CITY OF ALBUQUERQUE

November 16, 2016

Re: Beehive Homes Phase 4
13450 Wenonah Ave SE
Traffic Circulation Layout
Engineer's/Architect's Stamp 10-31-16 (L23-D022)

WHEELCHAIR RAMP DETAIL (TYP.)
NTS

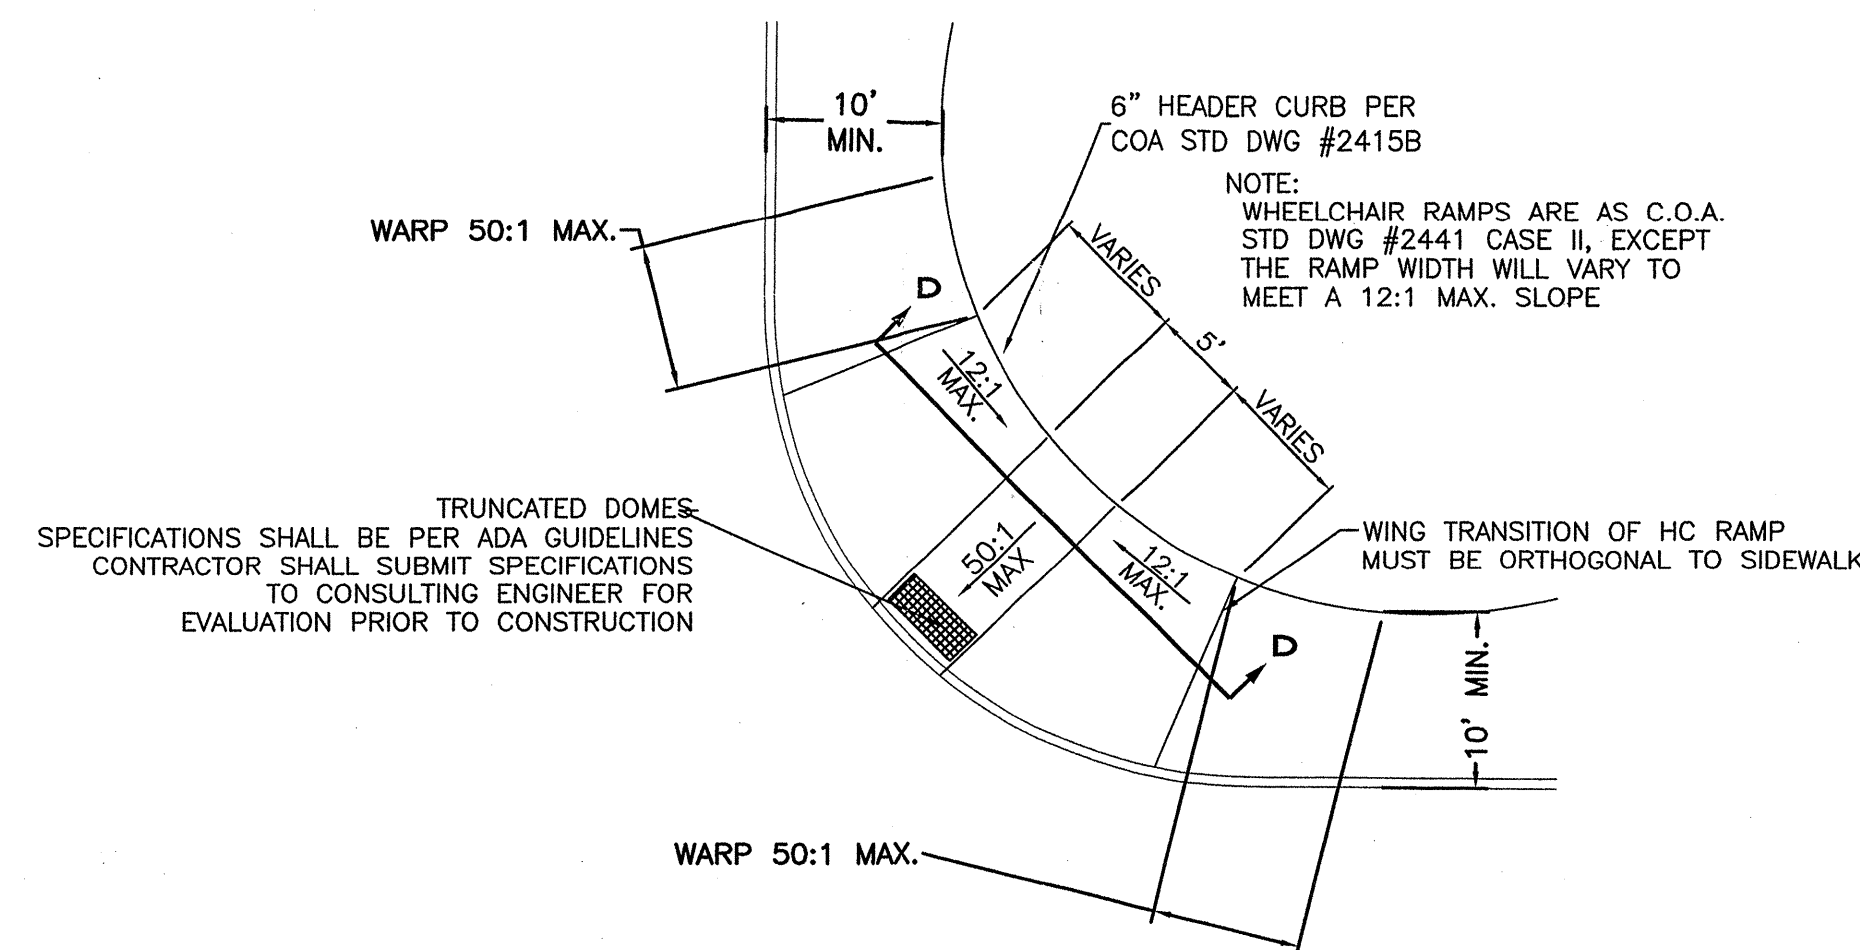
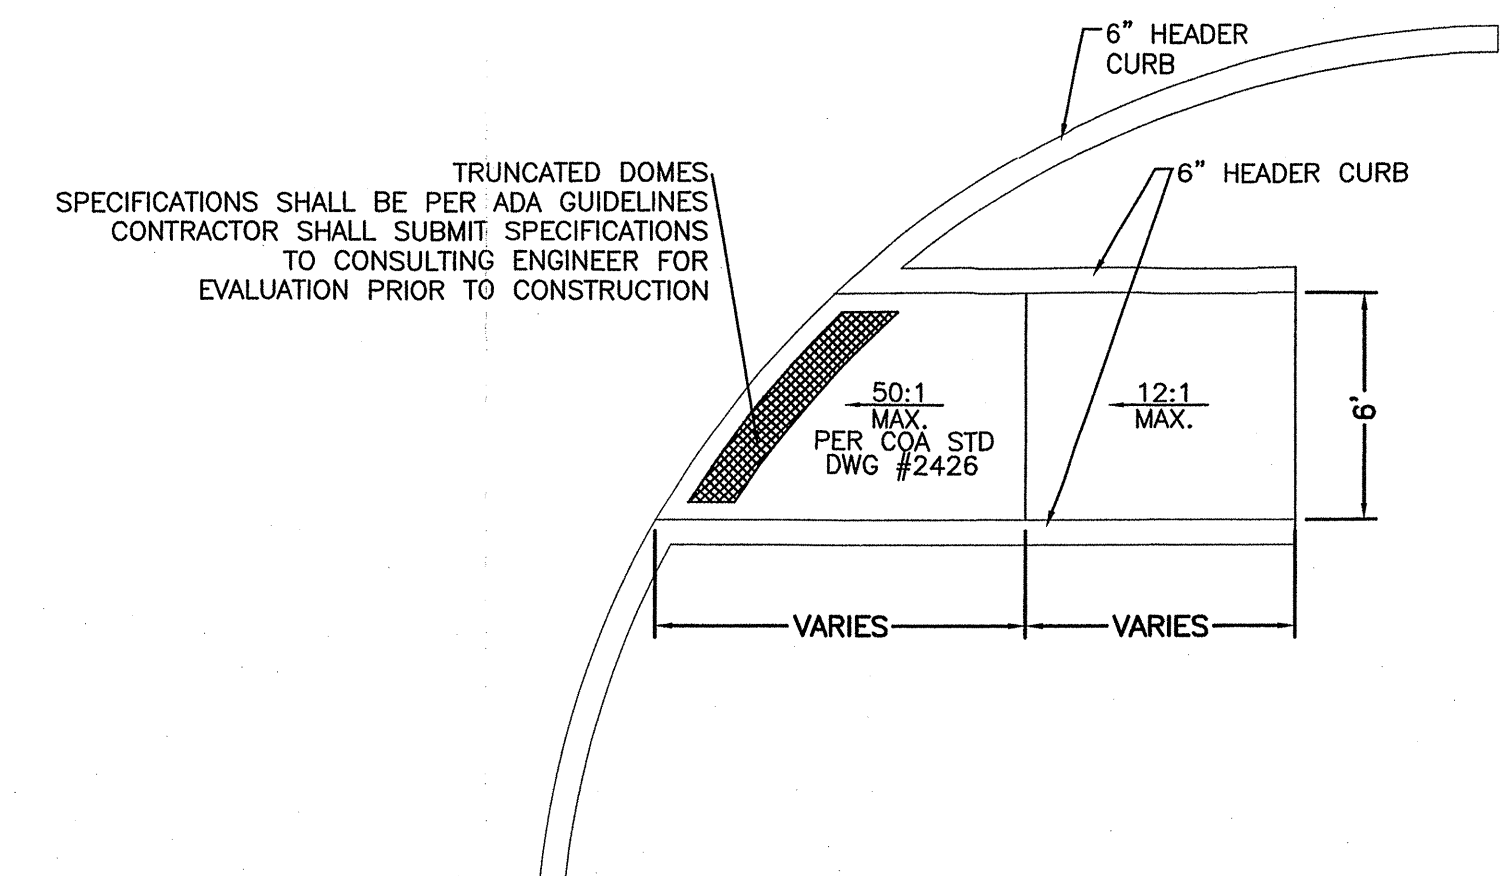
1. Provide details of widths and slopes of ADA ramps.
2. Please provide a copy of the plat with the shared access agreement with the adjacent property owner.
3. Provide an ADA accessible pedestrian access gate through the fence.
4. Keyed note 9 should say 4" stripe for the parking and I am counting 16 parking spaces provided not 17.
